U321 Land East of High Road, High Cross, Hertfordshire: Stage 1 Road Safety Audit Response For M Scott Properties
November 2023

# DESIGNERS RESPONSE: LAND EAST OF HIGH ROAD, HIGH CROSS – PROPOSED ACCESS

# Stage 1 Road Safety Audit Sutes Farm, Ermine Street, Ware Residential Access Arrangements

Date: 03/11/2023

**Drawing CCE U321-201-P05** – Proposed Site Access Layout

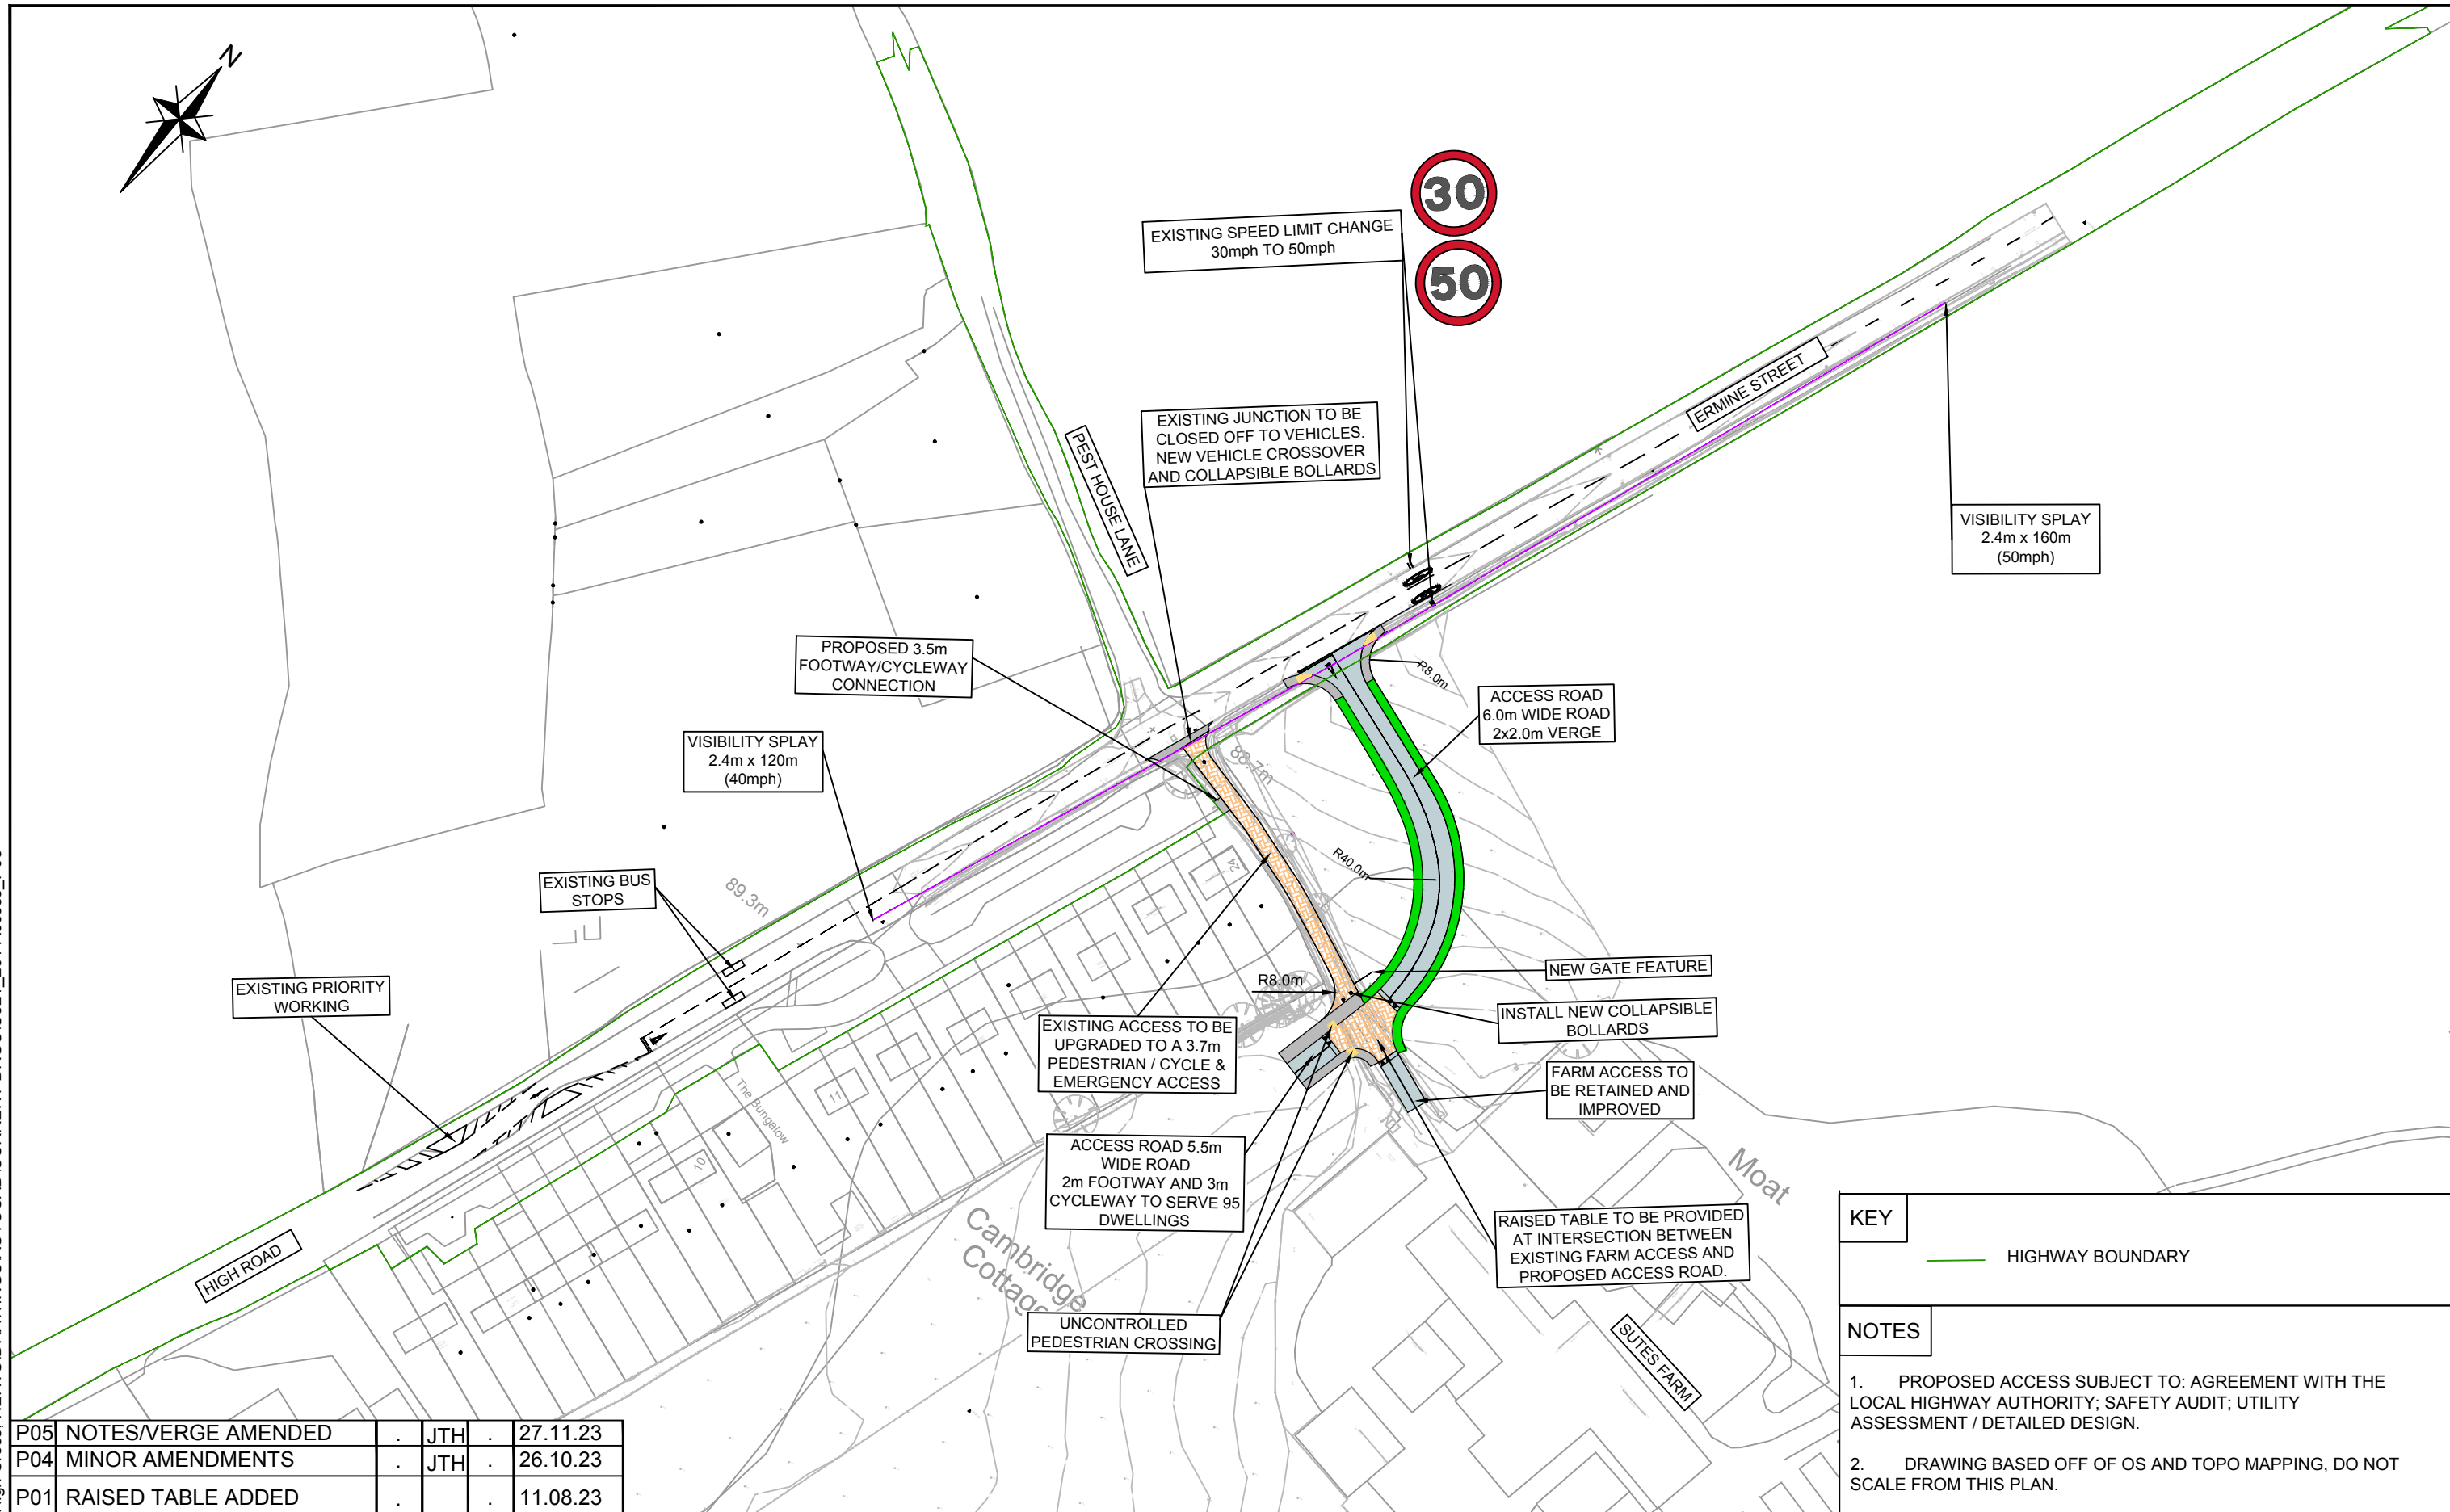
It is acknowledged that a 2.4m x 160m visibility splay to the right is proposed at the junction (this appears to be appropriate for the measured vehicle speeds provided), however, it is unclear whether the banking and existing vegetation will reduce the available visibility to the right for emerging users. Reduced side road visibility may lead to failure to give way type collisions.

It is recommended that adequate side road visibility to the right is provided, consistent with free flow 85<sup>th</sup> percentile approach speeds; this may require the re-profiling of the banking and removal of some vegetation.

At the junction, the adjacent ground levels are higher than the carriageway channel level. This may lead to a downhill gradient to the give way line. A downhill approach to the junction may lead to overshoot failure to give way type collisions, particularly in wet or icy conditions.

It is recommended that a flat dwell area is provided on the development arm of the junction on the approach to the give way line, consistent with current best practice.

At the proposed raised table junction pedestrians and other mobility impaired users may wish to cross the development access road. There appears to be no dropped kerb crossing point to facilitate such movements and this may present hazards for users, with upstand kerbs, or flush kerbs that may confuse sight impaired users. These issues may lead to hazards for mobility impaired or sight impaired users and to vulnerable user injury.

It is recommended that likely vulnerable user desire lines are assessed and suitable crossing provision made. Away from crossing points detectable kerb heights should be provided to assist sight impaired users to negotiate the junction area.

At the proposed High Road emergency access (also to be a dual use shared footpath link), it is unclear how cyclists will be returned to the carriageway, or encouraged to leave the carriageway to access the facility. The lack of appropriate facilities may lead to an increased likelihood of cycle to vehicle collisions, particularly involving cyclists turning right from the High Road on to the dual use facility.

It is recommended that the need for suitable crossing facilities at this location is assessed, to ensure cyclists can safely access / egress the proposed dual use facility.

The existing street lighting provision terminates at the junction with Pest House Lane. The proposed access is to be located to the north of the Pest House Lane junction and this may mean that the proposed development access junction is in shadow. Reduced illumination levels at, and on the approach to, the junction may lead to increased likelihood of collisions during the hours of darkness.

It is recommended that adequate illumination levels are provided, to highlight the presence of the proposed junction area and the main road approach. An extension to street lighting to the north of the proposed access area may require the relocation of the existing speed limit terminal – see also Observation 4.1 below.

Item	Problem	Auditor's Recommendation	Designer's Response	Highway Authority
		Addition 3 Necommentation	posignor s nesponse	Response
3.1 Junctions - 3.1.1	Location: Ermine Street at the development access Summary Review Reduced side road visibility may lead to failure to give way collisions.  It is acknowledged that a 2.4m x 160m visibility splay to the right is proposed at	It is recommended that adequate side road visibility to the right is provided, consistent with free flow 85 <sup>th</sup> percentile speeds. This may require the reprofiling of the banking and removal of some vegetation.	Accepted.  A vertical profile of the visibility splays at the site access has been prepared drawing U321-PL-SK-208. This demonstrates that visibility splays to the right are not affected by the banking.  Visibility splays will be provided in accordance with the posted speed limit, and will be cleared of vegetation and or banks re-profiled

the junction (this appears to be appropriate for the measured vehicle speeds provided), however, it is unclear whether the banking and existing vegetation will reduce the available visibility to the right for emerging users. Reduced side road visibility may lead to failure to give way type collisions.		where required to ensure they remain free from obstruction. This will form part of the detail design.

3.1.2	Location: Ermine Street at the development access Summary Review Side road downhill gradient may increase the likely of overshoot failure to give way type collisions.	It is recommended that a flat dwell area is provided on the development arm of the junction on the approach to the give way line, consistent with current best practise.	Accepted.  The access road profile will be designed in accordance with standards. This will form part of the detail design.	
	At the junction, the adjacent ground levels are higher than the carriageway channel level. This may lead to a downhill gradient to the give-way line. A downhill approach to the junction may lead to overshoot failure to give way type collisions, particularly in wet or icy conditions.

3.2 Walking, C 3.2.1	Cycling and Horse Riding – Problem	It is recommended that likely		
0.2.1	Location: At the internal development junction with Sutes Farm access  Summary Review  Unmet pedestrian crossing routes may lead to hazard for mobility impaired users.	vulnerable user desire lines are assessed and suitable crossing provision made. Away from crossing points detectable kerb heights should be provided to assist sight impaired users to negotiate the junction area.	Accepted.  Pedestrian crossing points will be designed and provided in accordance with standards and RM layout design and detail design.	
	At the proposed raised table junction pedestrians and other mobility impaired users may wish to cross the development access road. There appears to be no dropped kerb crossing point to facilitate such movements and this may present hazards for users, with upstand kerbs, or flush kerbs that may confuse sight impaired users. These issues may lead to hazards for mobility impaired or sight impaired users and to vulnerable user injury.

3.2.2	Location: At the proposed emergency access on to High Road.  Summary Review  Lack of cycle route continuity may lead cycle to vehicle collisions.  At the proposed High Road emergency access (also to be dual use shared footnath link) it is unclear how cyclists.	It is recommended that the need for suitable crossing facilities at this location is assessed to ensure cyclists can safely access / egress the proposed dual use facility.	The cycle route will be via the High Road (service road), where a transition kerb will be provided, leading cycles onto a quiet length of carriageway.  From the service road, cyclists can transition onto High Road and into the village, at the junction.  Where the proposed emergency access meets	
	footpath link), it is unclear how cyclists will be returned to the carriageway, or encouraged to leave the carriageway to access the facility. The lack of facilities may lead to an increased likelihood of cycle to vehicle collisions, particularly involving cyclists turning right from the High Road on to the dual use facility.		High Road, suitable vehicle transition kerbs can be provided that facilitate emergency access but provide a deterrent to cycles.

3 3 Traffic Sin	ns, Carriageway Markings and Lighting	- Problem		
3.3.1	Location: Ermine Street, at the development access.  Summary Review  Reduced illumination levels may lead to increased likelihood of collisions during the hours of darkness.  The existing street lighting provision terminates at the junction with Pest House Lane. The proposed access is to be located to the north of the Pest House Lane junction and this may mean that the proposed development access junction is in shadow. Reduced illumination levels at, and on the approach to, the junction may lead to increased likelihood of collisions during the hours of darkness.	It is recommended that adequate illumination levels are provided, to highlight the presence of the proposed junction area and the main road approach. An extension to street lighting to the north of the proposed access area may require the relocation of the existing speed limit terminal.	Accepted. The need for street lighting will be considered at detail design.
